ARUN DISTRICT COUNCIL				
No.	BN	27	09	
Received

11th February 2010

Angel's Nursery, Barnham – BN/27/09

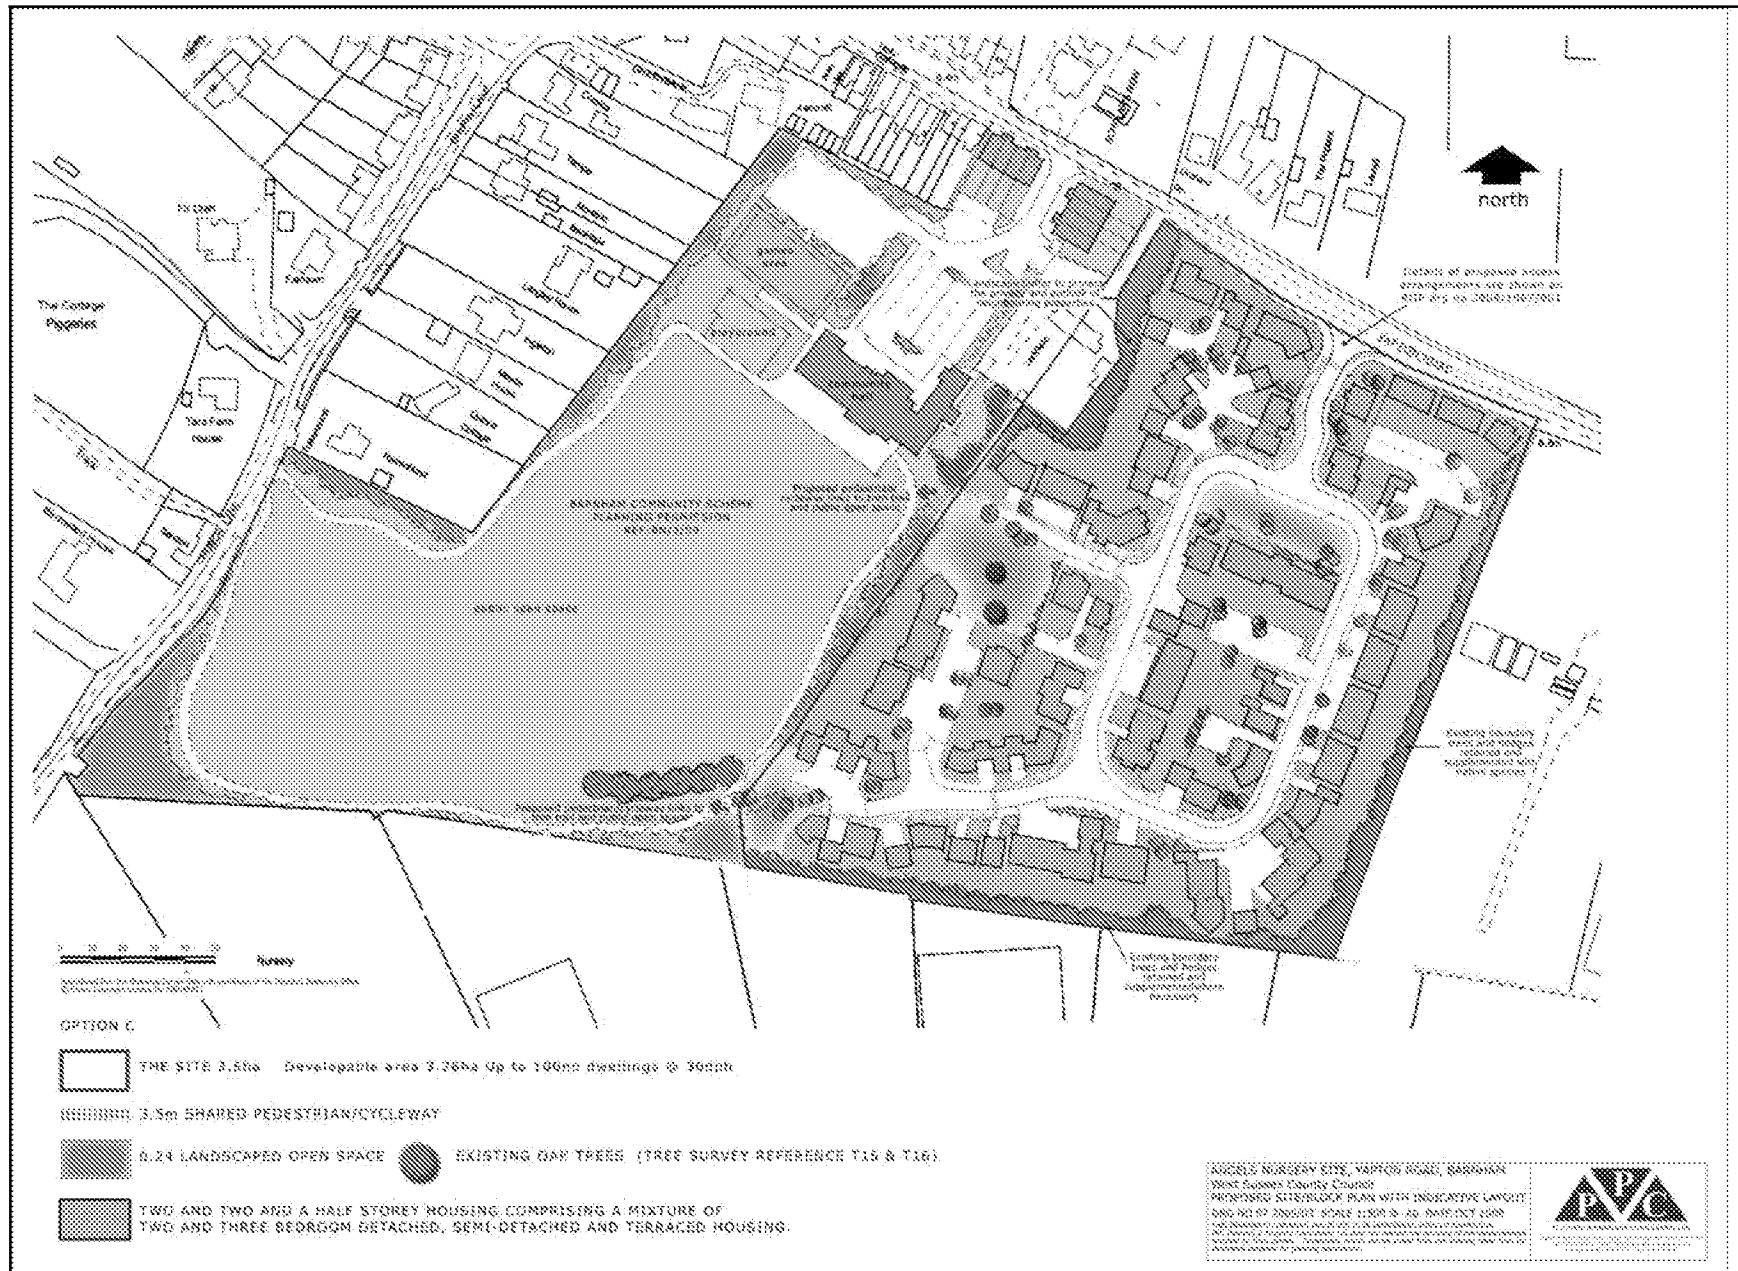
Can you confirm which trees are proposed to be retained in your indicative layouts you have submitted? All that is apparent from the indicative layouts is the existing boundary treatment on the south and east boundary and the two Oak trees within the proposed open space (T15 and T16). However, the absence of RPA does not allow the Council to confirm that the layouts ensure these remain. Any such vegetation to be retained must be suitably protected for the development work by appropriate fencing. This will need to be identified on a plan.

The western boundary landscaping appears differently on each of the three indicative layouts without annotation and no northern boundary landscaping is shown - this must be included. There is also no indication of any other trees or hedgerows within the site being retained. The Council consider that the Group T18-23 should be retained as part of any layout and acknowledge that this has a significant impact on potential layouts and developable areas. However, these are mature and highly prominent trees with no significant defects.

With provision of LEAP's on the adjoining site, it is considered that the LAP should be more centrally located in the indicative layouts so that the use is principally from residents of the proposed scheme where every proposed dwelling has good access to it.
